Monument Ridge East RS-6000 Zoning Map

NW1/4 Section 2, Township 11, Range 67 W 6th PM

Request: Request for
approval of a map
amendment (rezone) of 40.51
acres to the RM-12
(Residential Multi-Dwelling)
zoning district.

Monument Ridge East RS-6000 Zoning Map

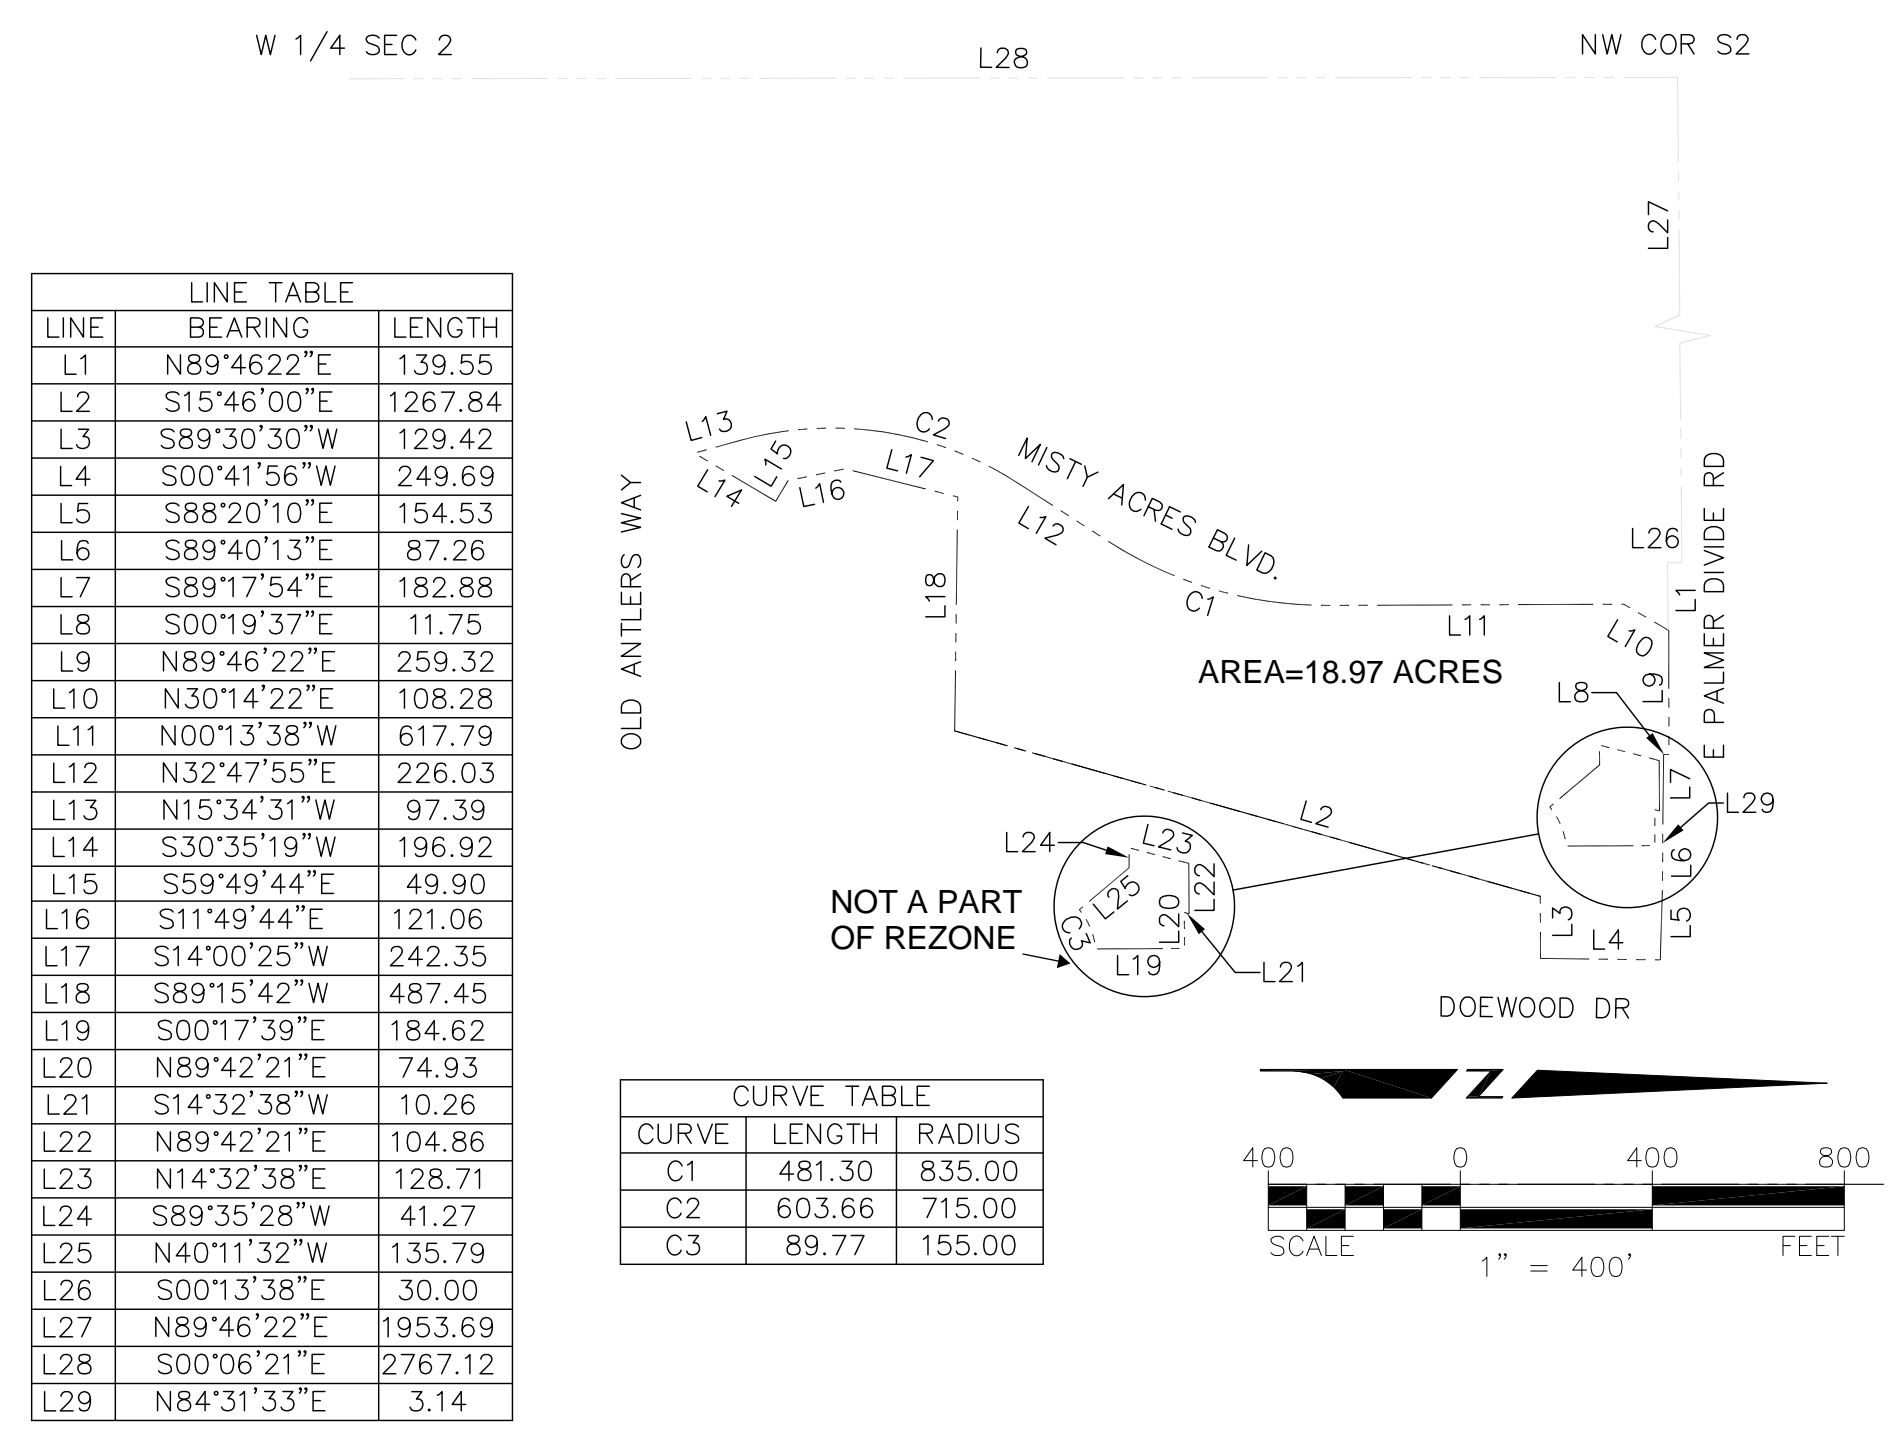
Remove colors

The road does not
continue here

Is this part of the
rezone? If not remove
from exhibit

Street is over
residential lots and on
the zoning label,
move label to the
correlating street

This is for the
RS-6000 rezone not
RM-12. Needs to be
updated

Is this included or
excluded in the
rezone. If that

Provide legal description of the proposed rezone

Remove Line labels
on the map

Label the zoning district for
the light tan residential area

Scale is not accurate

Scale is incorrect.
Provide accurate
scale for the image
